DELEGATED DECISION TO DETERMINE PLANNING APPLICATIONS

Reference No:	2023/62/93296/E
Site Address:	75a, North Road, Kirkburton, Huddersfield, HD8 0QE
Description:	Conversion and alterations of existing office into living accommodation (within a Conservation Area)
Recommending Officer:	Elenya Jackson

DECISION – CONDITIONAL FULL PERMISSION

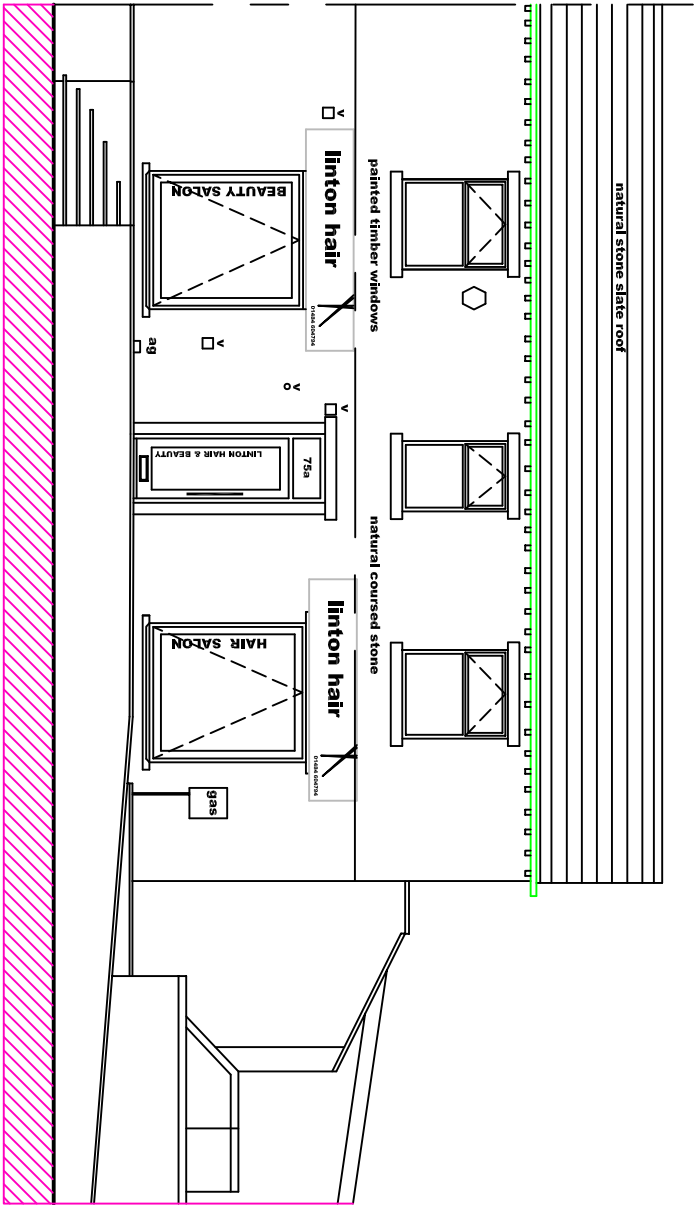
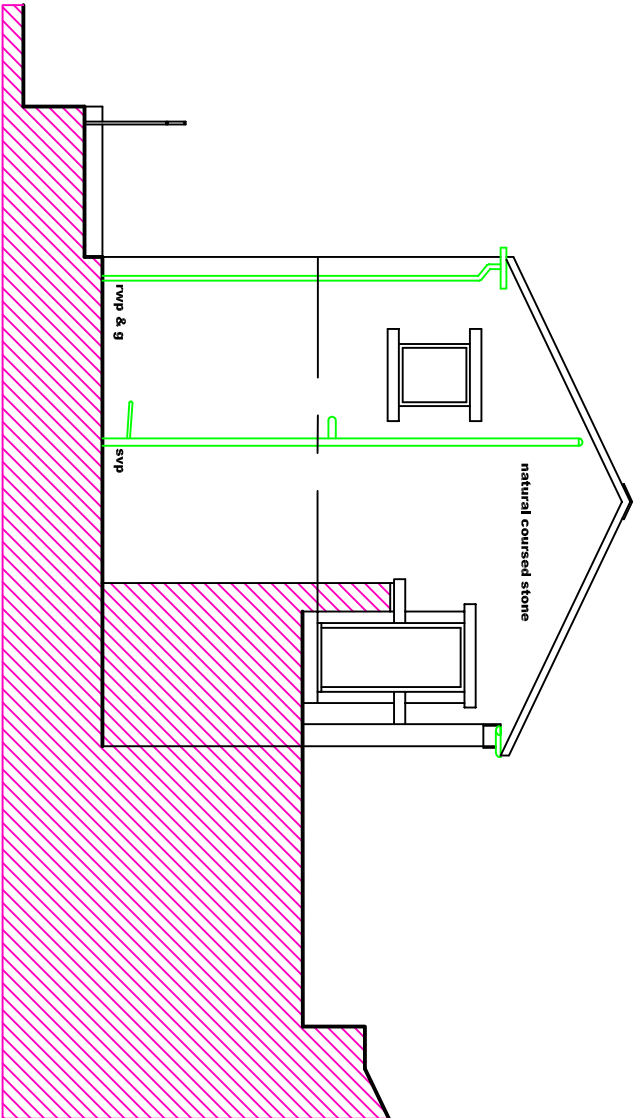
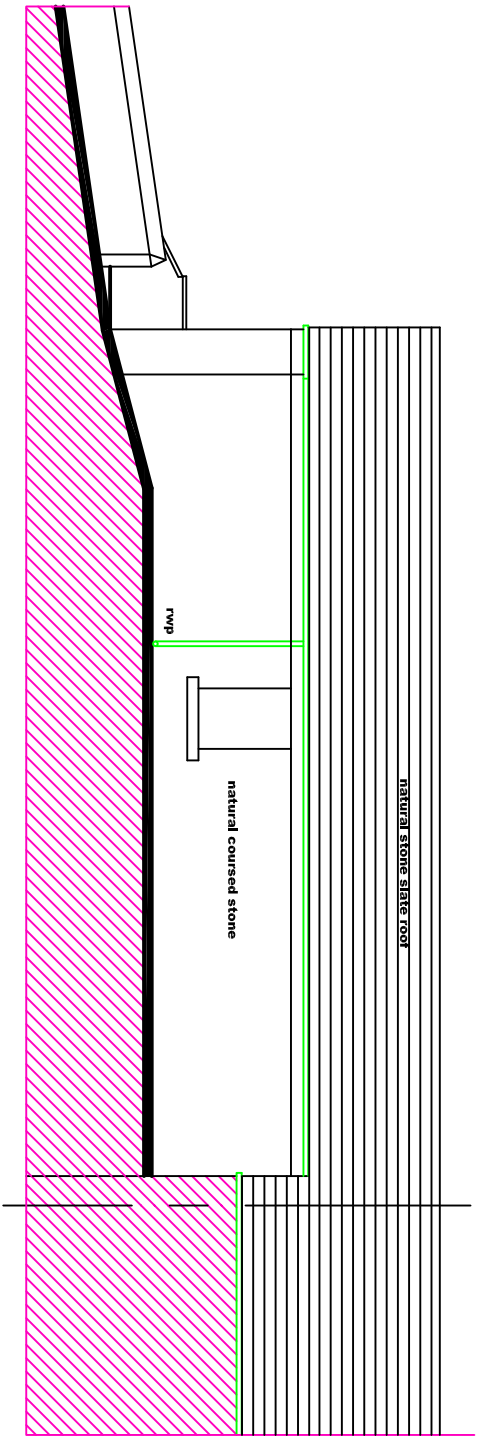
In this case, officers note that much of the proposed works would be internal in order to convert the existing property into a dwelling; however, there are the insertion of rear windows and alterations to the existing rain water goods via an additional down pipe on the gable elevation and rear elevation and an additional pipe running across the gable.

KC Conservation has been informally consulted on this application and has not raised any concerns providing that the rainwater goods are matching to those on the existing building.

3. The external rainwater goods of the development hereby approved shall in all respects match those used in the construction of the existing building and thereafter be retained.

drawing title
SITE PLAN

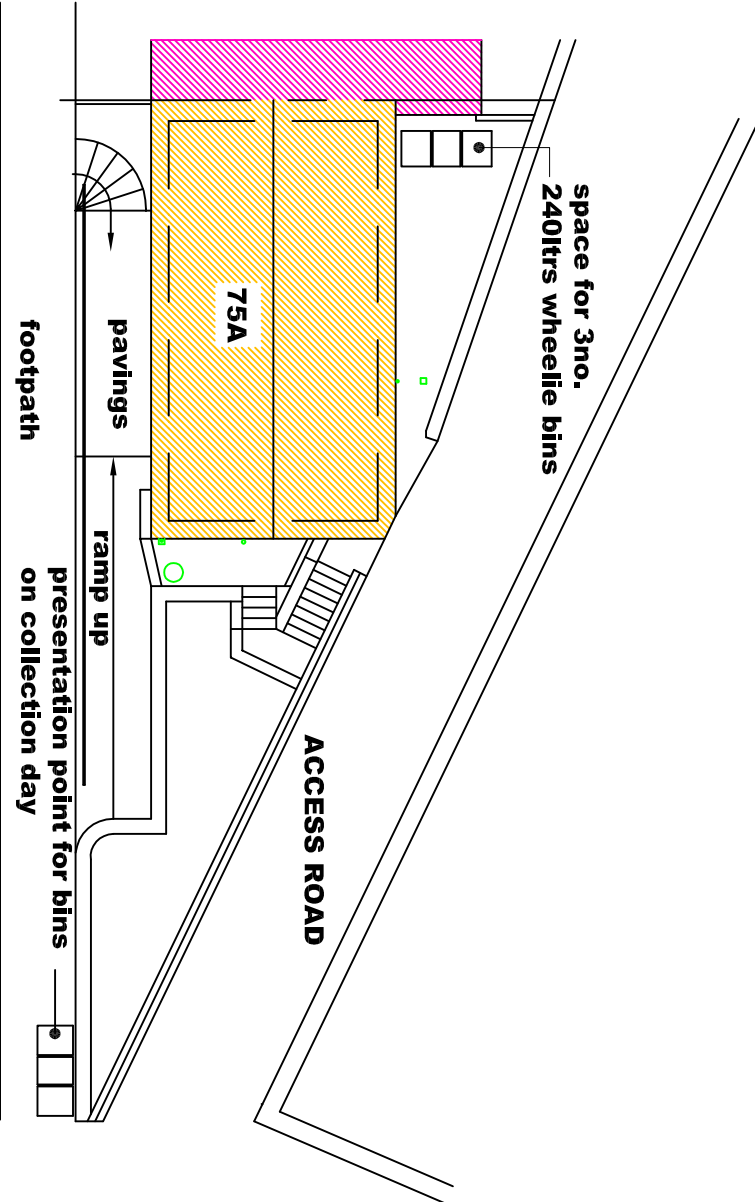
Additional plans were requested by officers to indicate where the refuse storage would be on site. KC Highways were shown these plans and no objections raised.

Officers requested the number of bedrooms on site was reduced and a site plan which shows the location of the bin storage.
